**Amended Concept Proposal for the Redevelopment of Cockle Bay Wharf  
Notification of Exhibition (SSD 7684)**

Thank you for your letter dated 14 November 2017, requesting Transport for NSW (TfNSW) to review and comment on the above. Roads and Maritime Services will provide a separate response.

## **TAB A – Detailed Comments on the Amended Concept Proposal for the Redevelopment of Cockle Bay Wharf**

ATTACHMENT B  
VEHICLE TURN PATHS

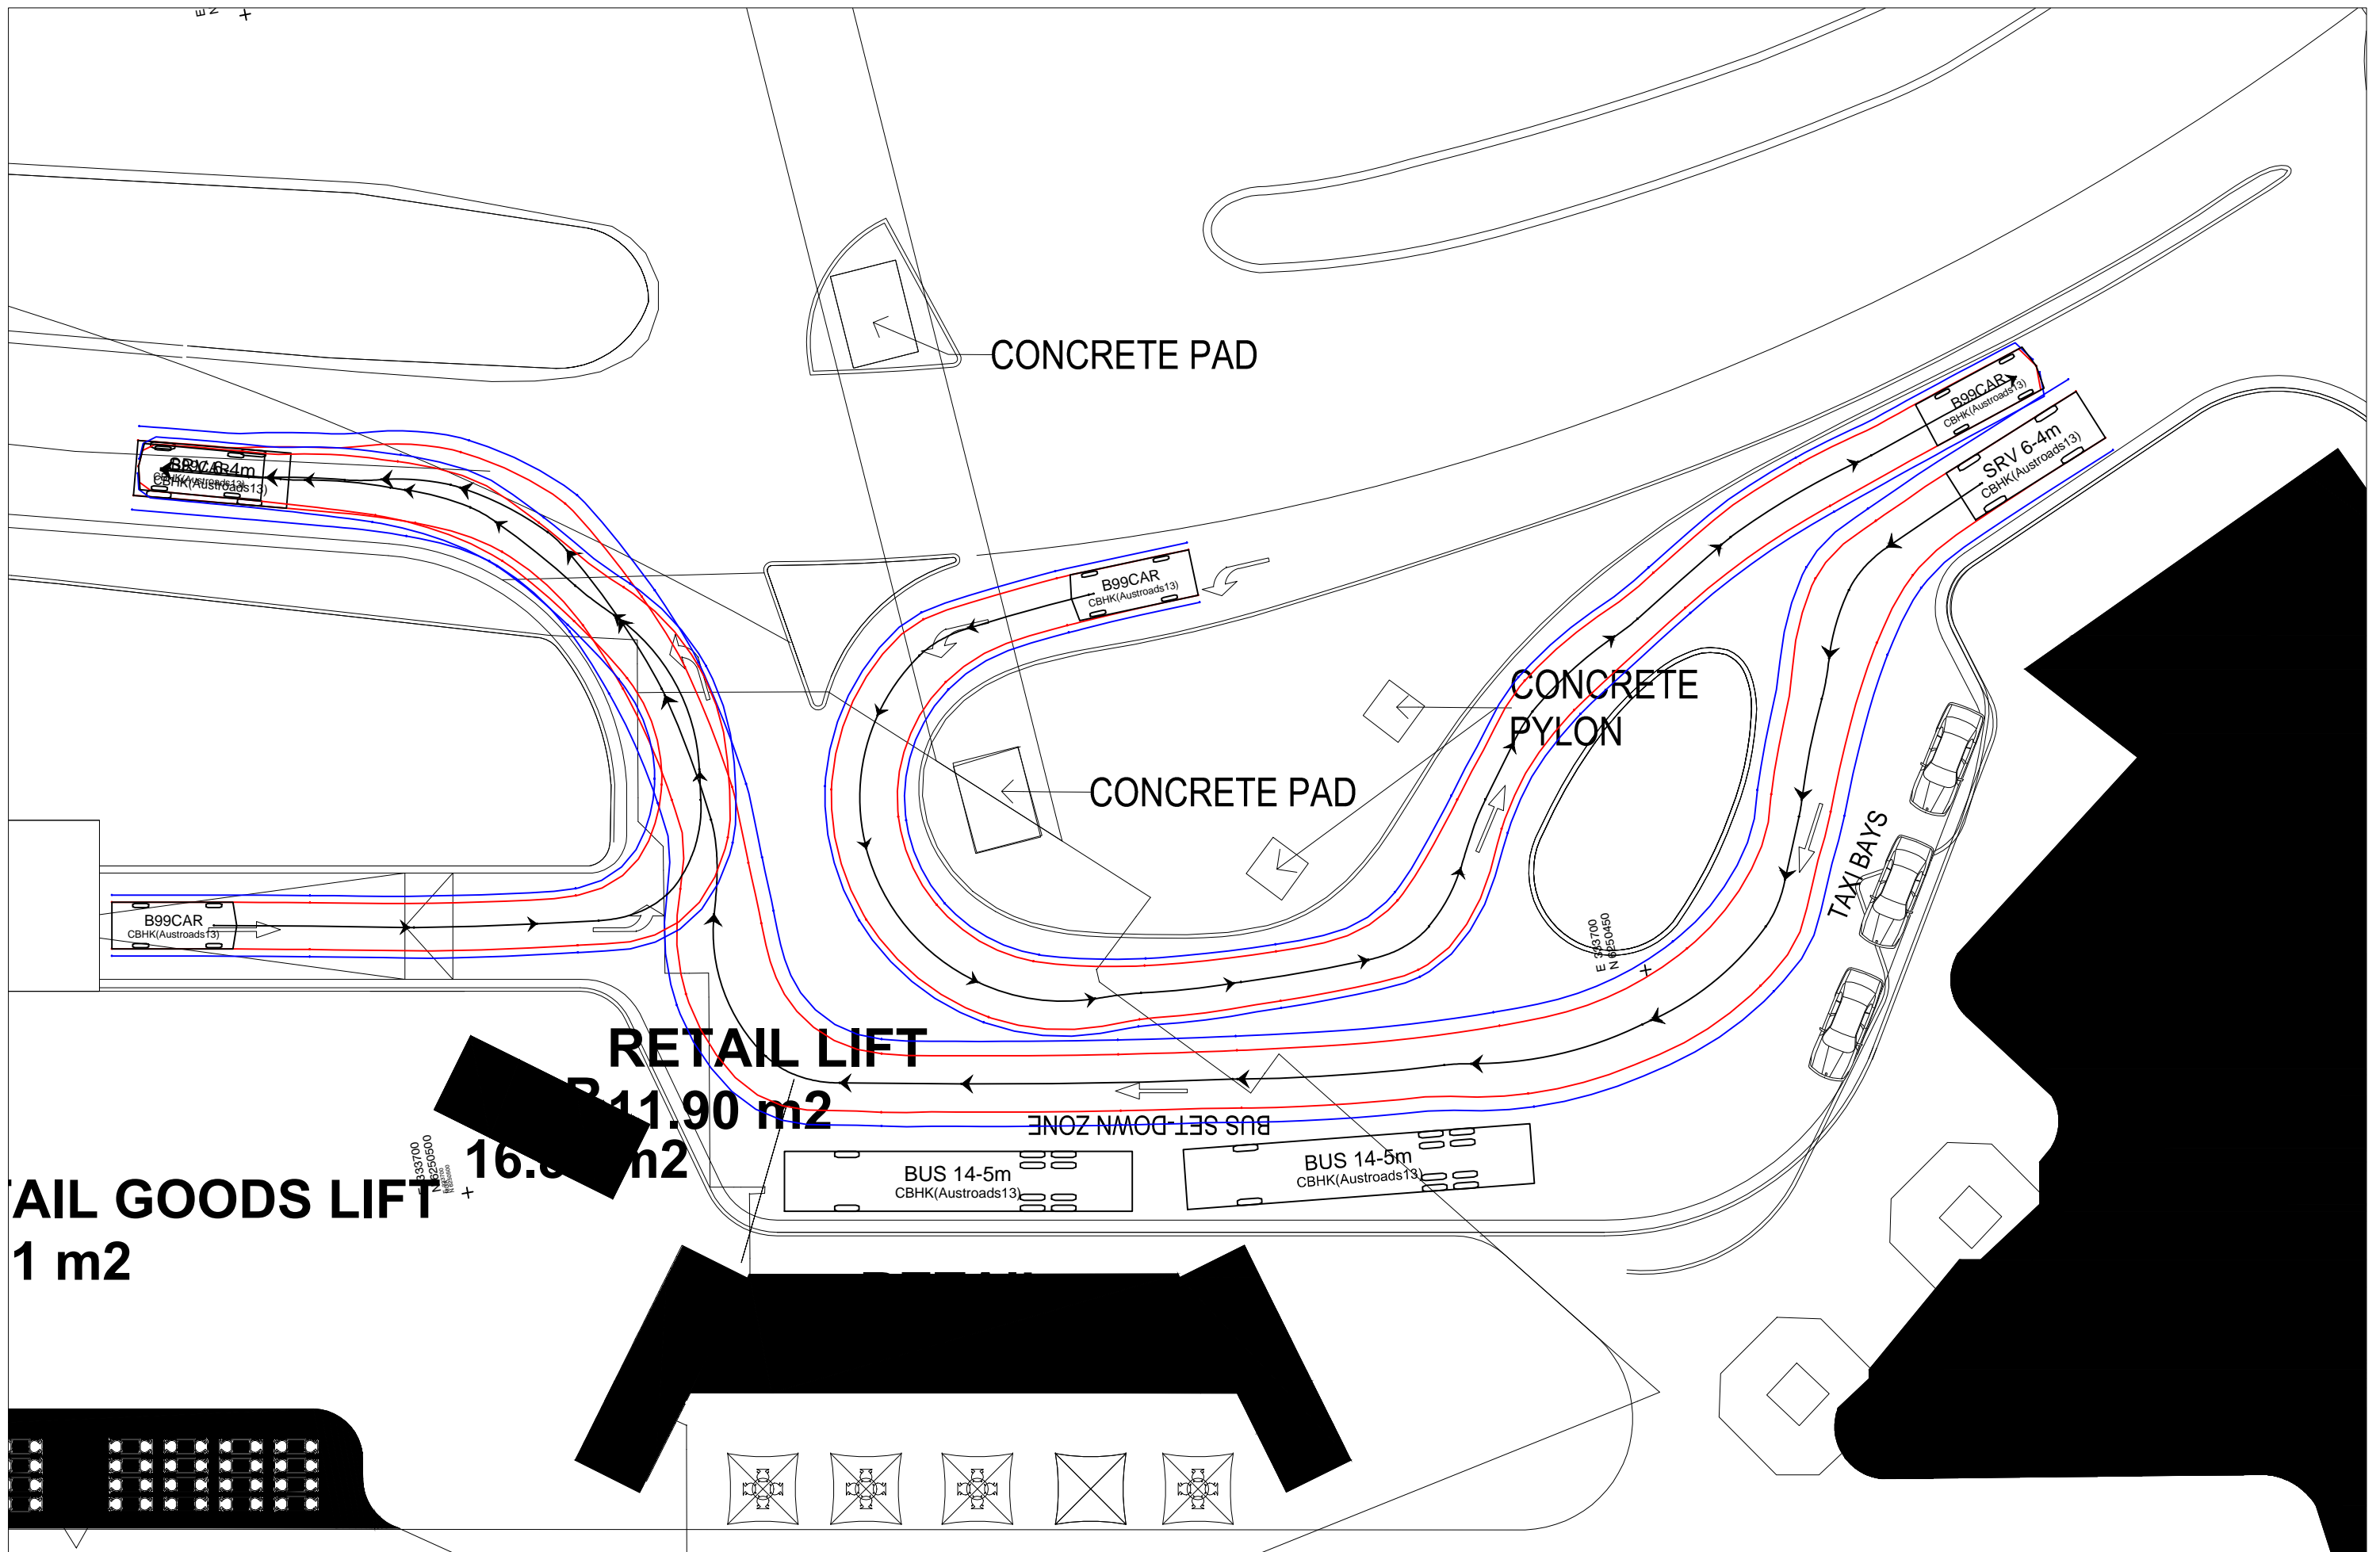
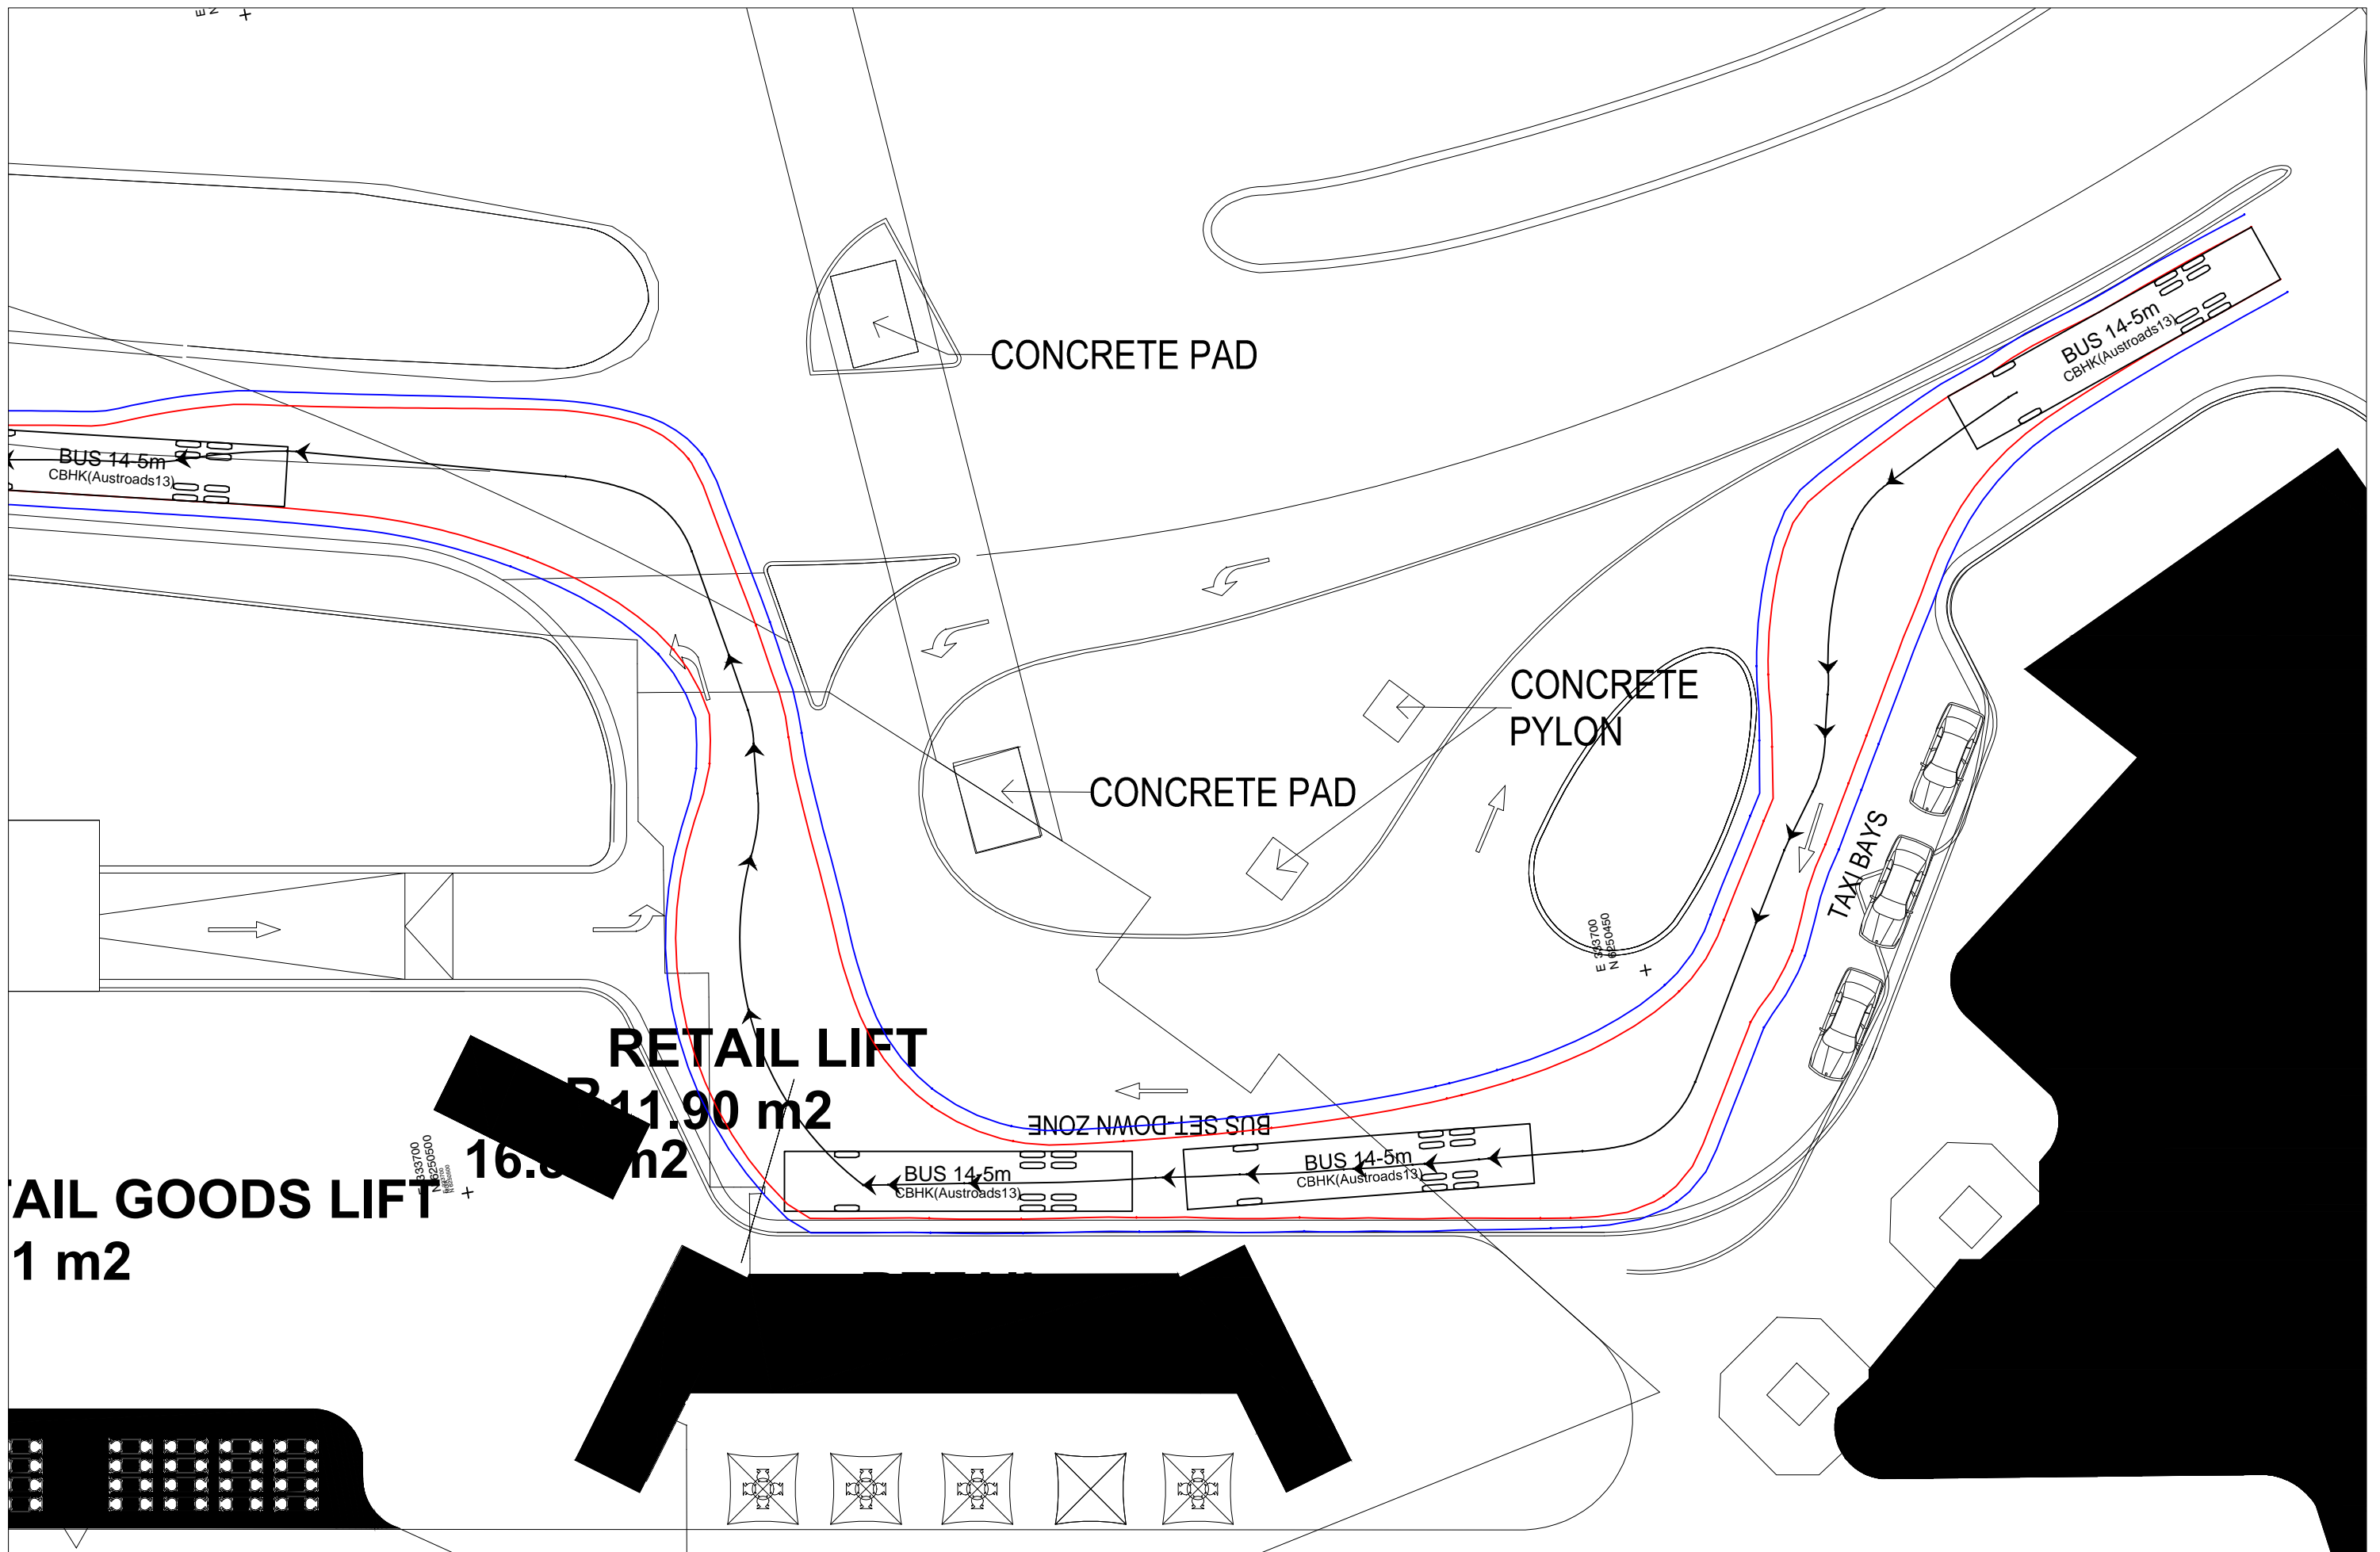
- The proposed left turn ingress into Wheat Road and associated modifications to the approved IMAX Theatre development's Porte Cochere and parking arrangement, as part of the proposed options for either a signalised left turn or left and right turn egress from Wheat Road to Harbour Street, do not align with the altered design and operation of the IMAX Theatre development's Porte Cochere and parking arrangement; and
- It is unclear if the proposed modifications to the approved IMAX Theatre development's Porte Cochere and parking arrangement also form part of the proposed priority controlled left-only turn from Wheat Road onto Harbour Street, as the vehicle swept paths provided at Attachment B are based on the proposed modified Porte Cochere and parking arrangement design.

- Any proposed changes to Wheat Road and the Wheat Road/Harbour Street intersection as part of the subject proposal align with the IMAX Theatre development and be investigated by a road safety audit that should be undertaken by an independent TfNSW accredited road safety auditor;
- The applicant ensures that traffic movements from vehicles associated with the operation of the IMAX Theatre development, particularly northbound traffic on Wheat Road, are not impacted; and
- The applicant clarifies if the proposed modifications to the approved IMAX Theatre development's Porte Cochere and parking arrangement also form part of the proposed priority controlled left-only turn from Wheat Road to Harbour Street and if so, investigate the changes by undertaking a road safety audit by an independent TfNSW accredited road safety auditor.
